**Subject: Avanzando Development Traffic Impact Study  
Southeast corner of NM 500 and Loris Drive  
Bernalillo County, New Mexico**

This letter is to inform you that the **FINAL** Traffic Impact Study (TIS) for Avanzando Development dated March 20, 2023 has been reviewed. The proposed development is located on southeast quadrant of NM 500 (Rio Bravo Blvd.) and Loris Drive.

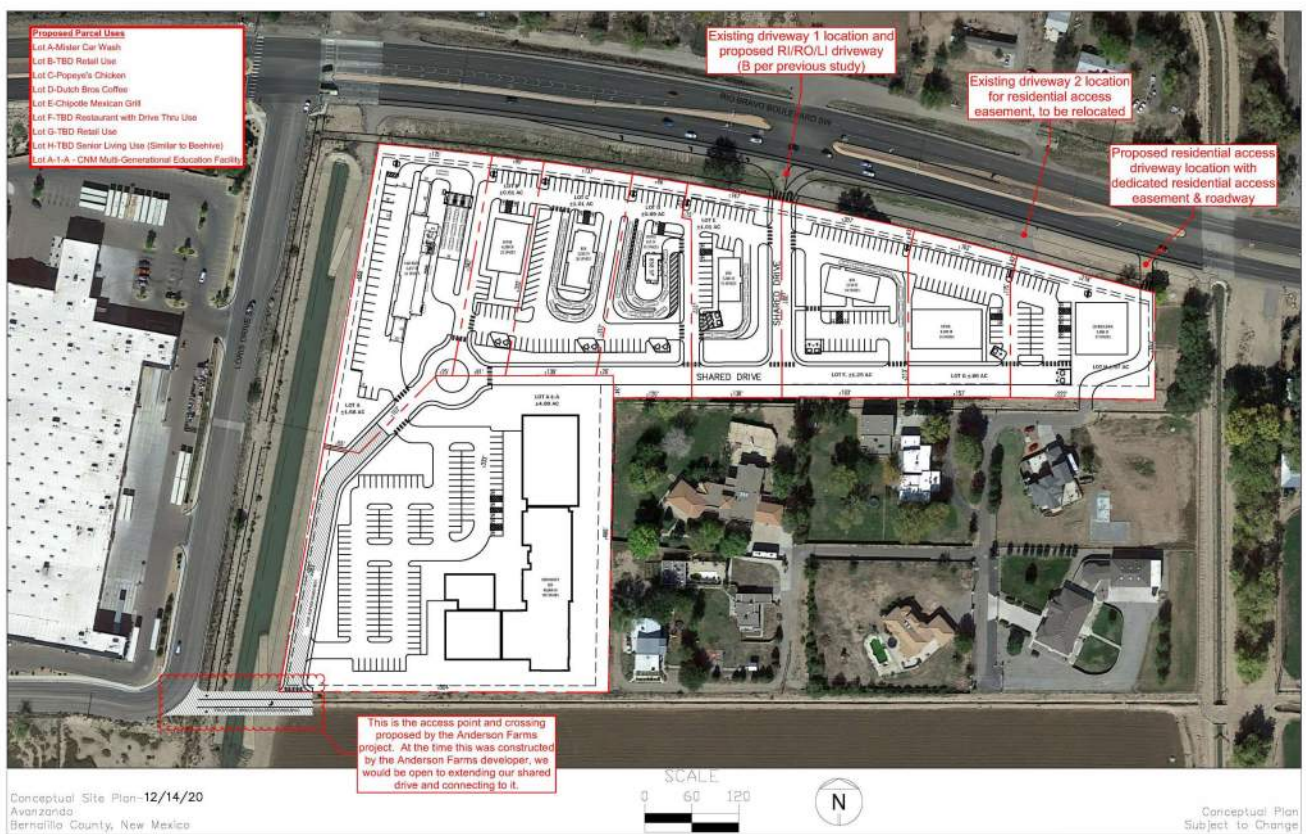
The NMDOT has no objection to one partial access located on NM 500. The partial access will be limited to right-in, right-out and left-in only. See Exhibit A for the access location and site plan. This study provided recommendations to mitigate its impacts, these are summarized in Exhibit B. Based on these analyses, NMDOT concurs on this development with the following conditions:

1. The property owner shall submit a Commercial Driveway Application for one partial access, right-in, right-out, left-in only on NM 500.
2. The development shall install an eastbound right deceleration lane at its access on NM 500 to a total length of 370-feet (220 feet plus 150-foot taper).
3. The development shall extend the existing westbound left deceleration lane at its access on NM 500 to a total length of 420-feet (270-feet plus 150-foot taper).
4. The development shall install median islands at the Avanzando Driveway to prevent a left-out egress movement.
5. The development shall install delineators across the median access for the Arenal Drain.
